MEMORANDUM

TO: Jean Fraser, Planner
FROM: David Senus, P.E.
DATE: February 20, 2013
RE: Final Level III Site Plan Application Response to Comments – Old Barn Estates

Woodard & Curran has reviewed the response to comments email and associated attachments received on February 20, 2013 for the Final Level III Site Plan Application for Old Barn Estates Subdivision off of Ledgewood Drive on the Falmouth/Portland line.

Drawing file: Submissions for Hearing 2.26.2013 / C-302 Site Details.pdf

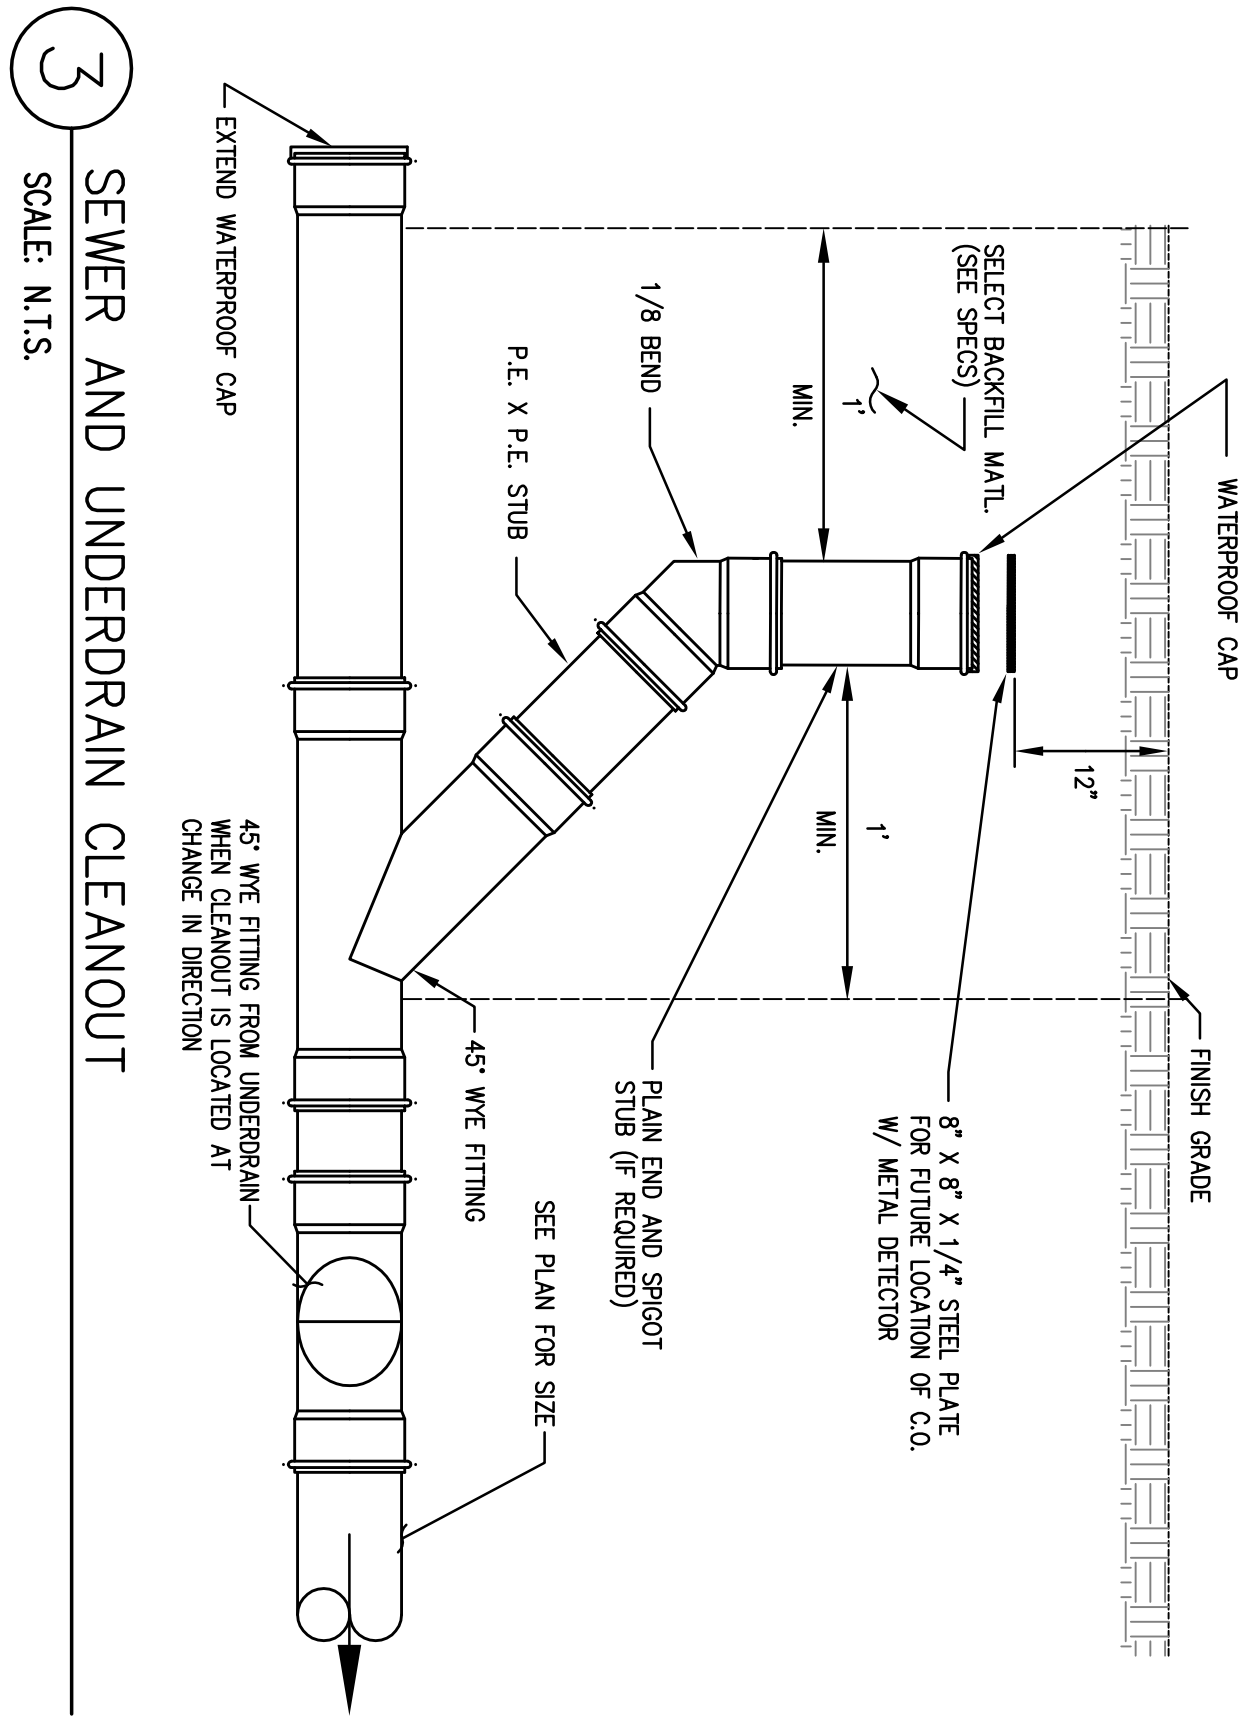
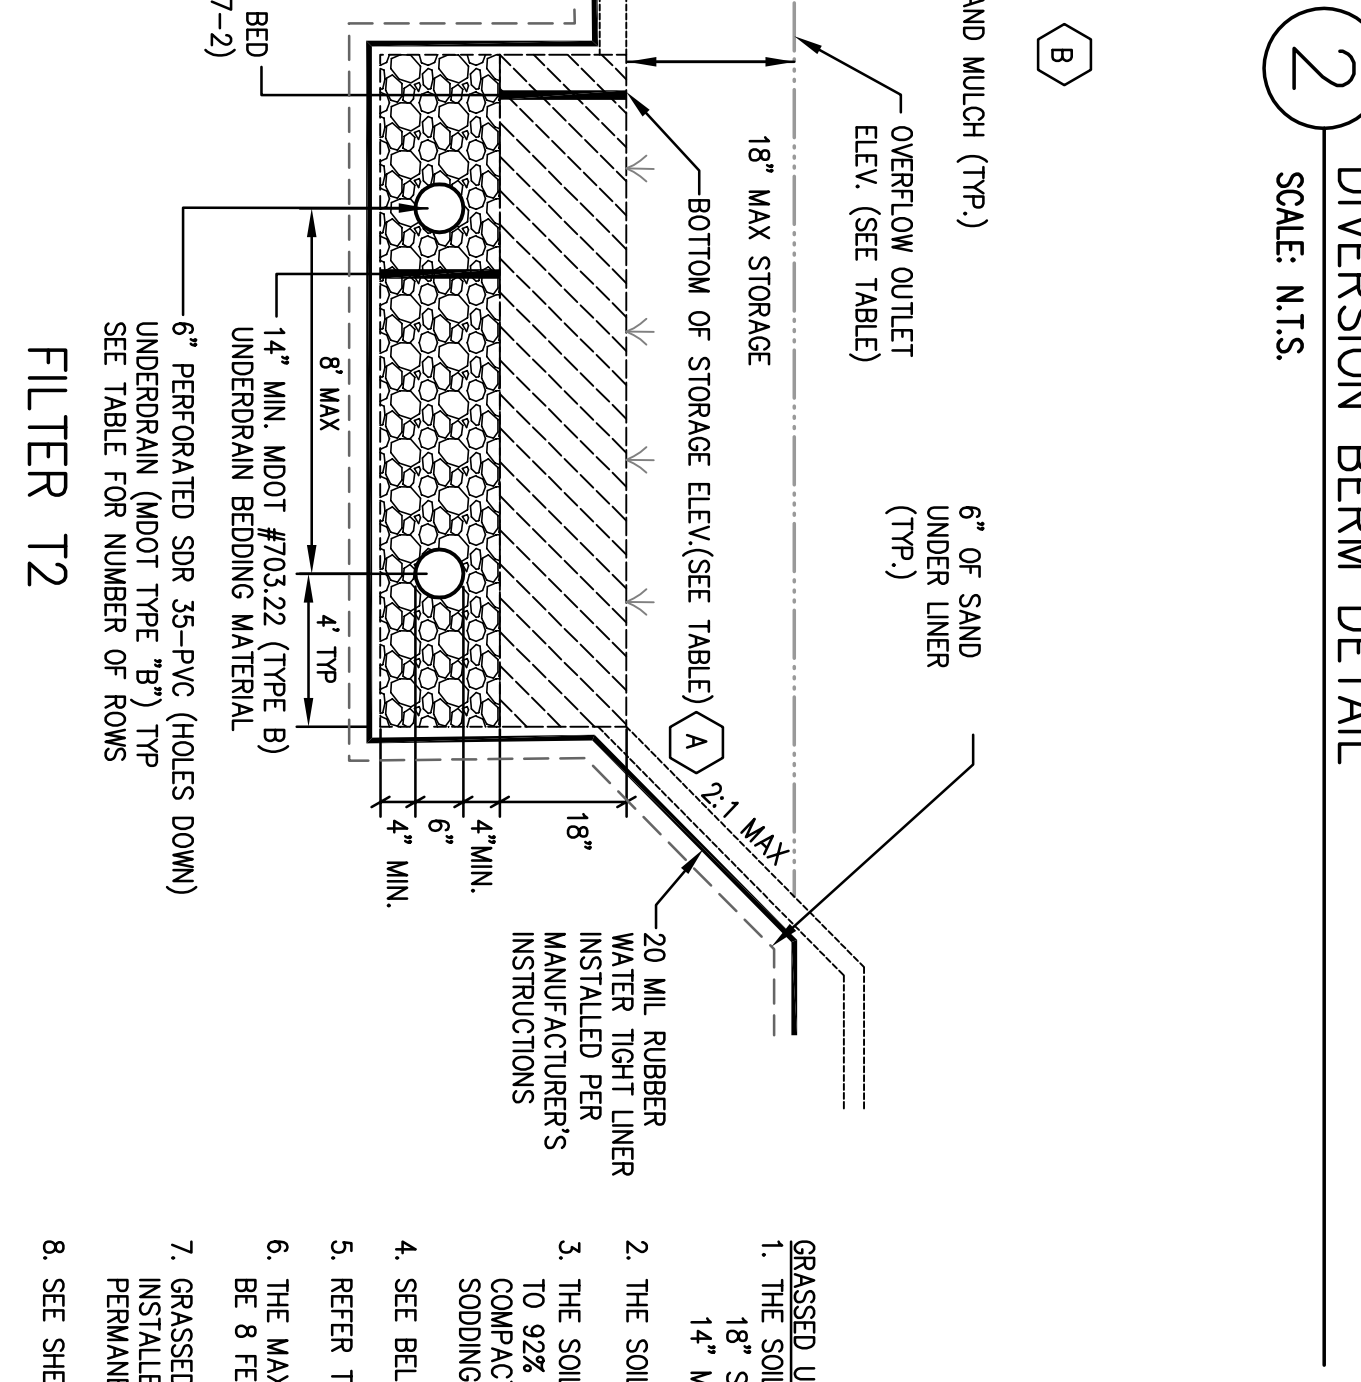
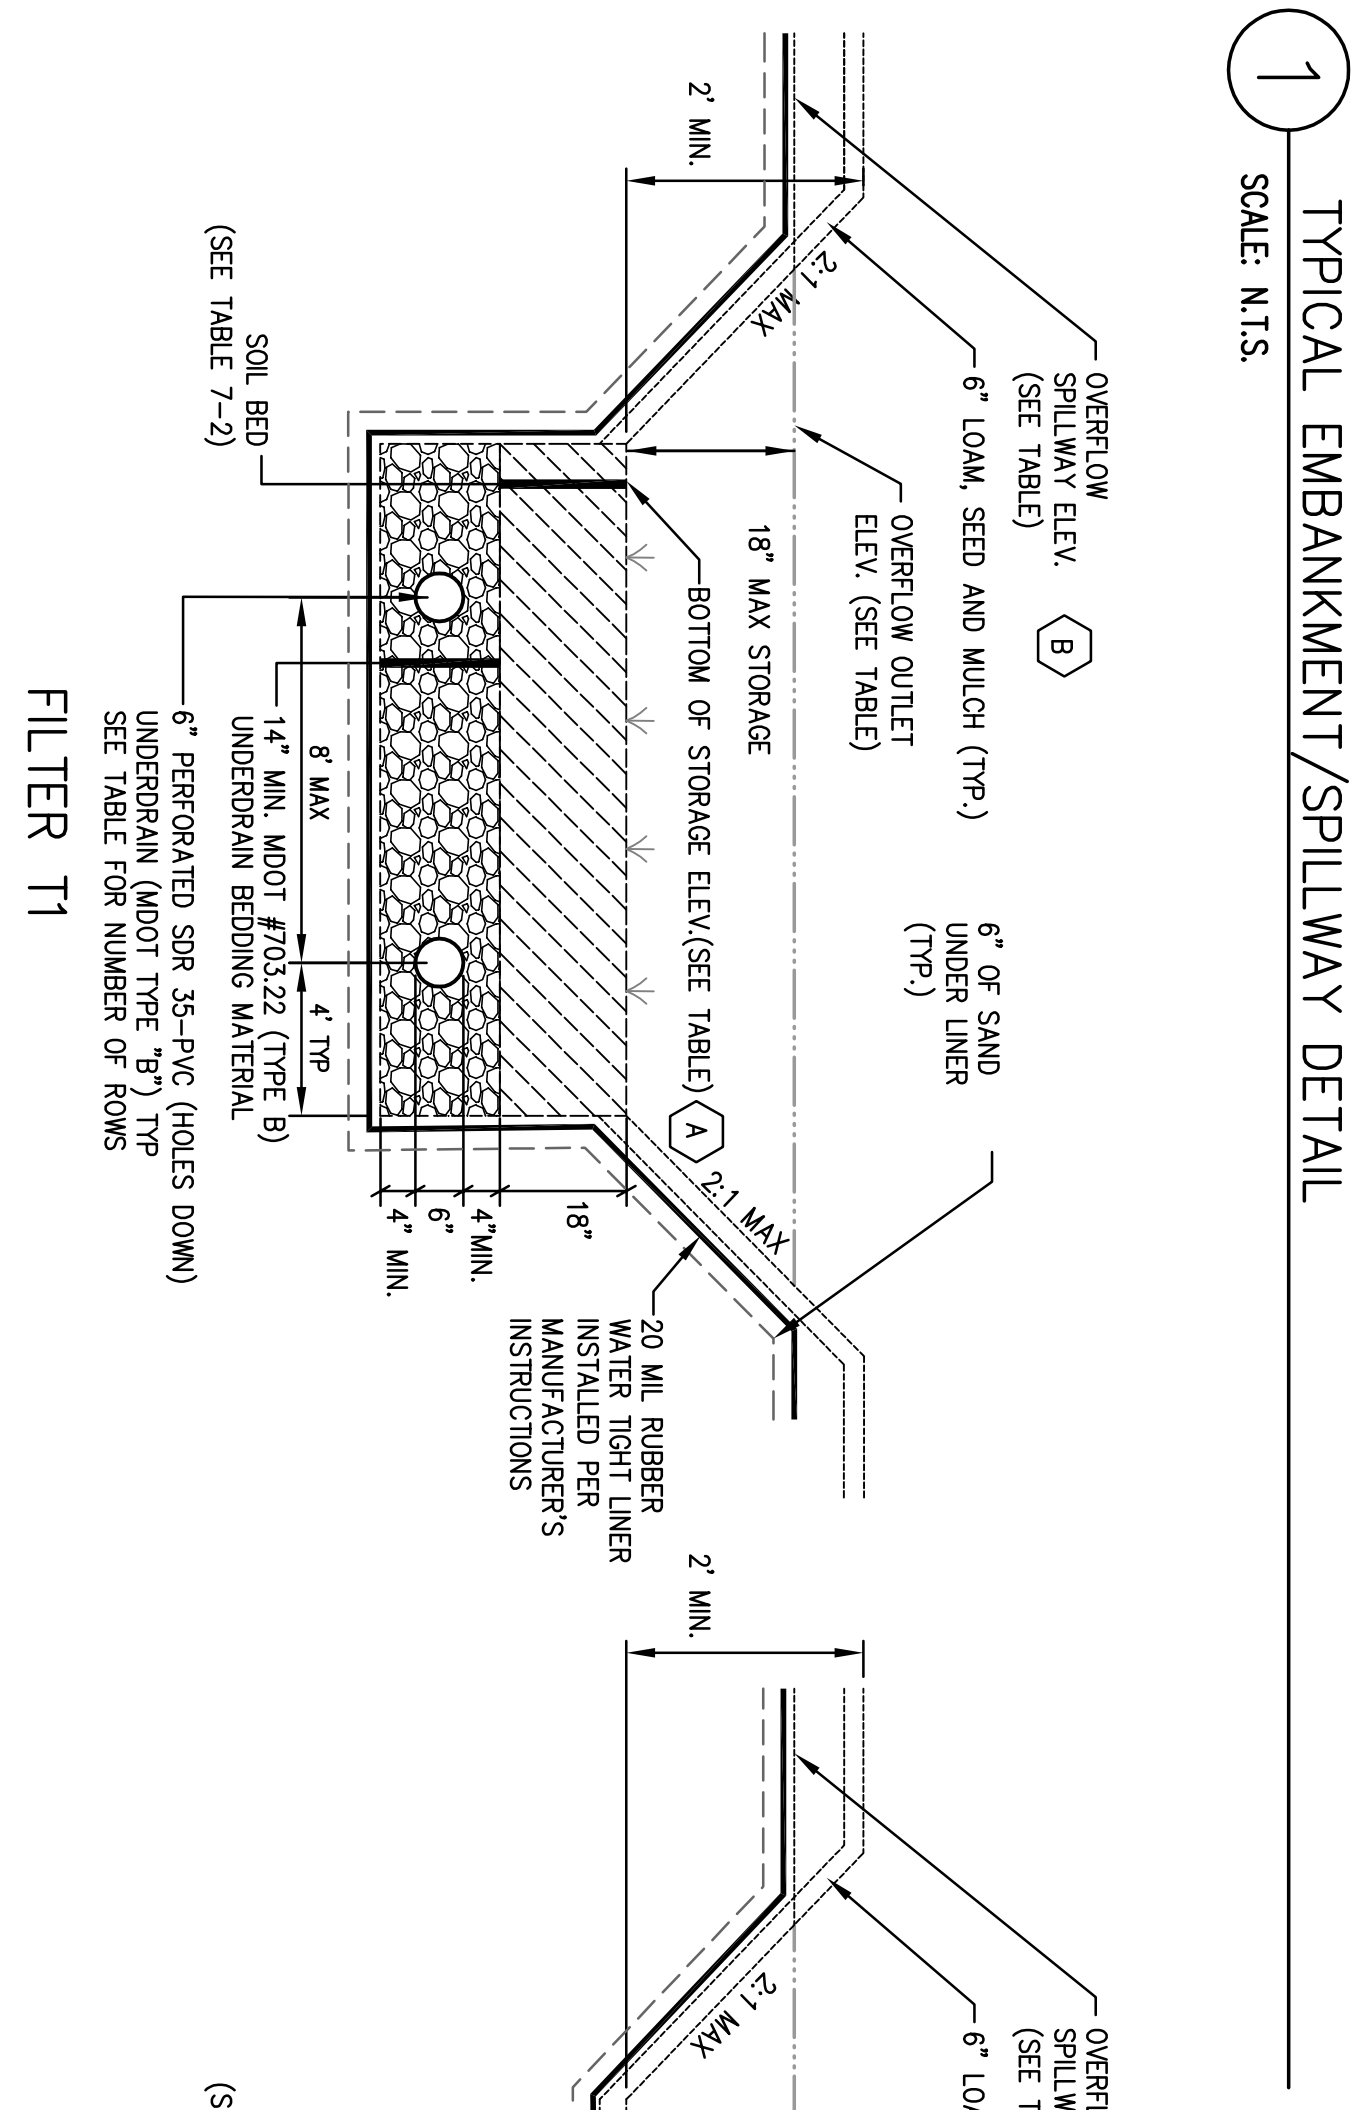
6. *Comment: Sheet C-201, Note 14 states that “Dripline filters shall be installed to capture all stormwater runoff from roofs of houses constructed on lots 7, 8, and 9. See detail on sheet C-302”. These details actually reside on sheet C-303.*

Applicant Response: Note 14 on C-201 now refers to the correct sheet for the dripline filter detail (C-303).

Comment adequately addressed.
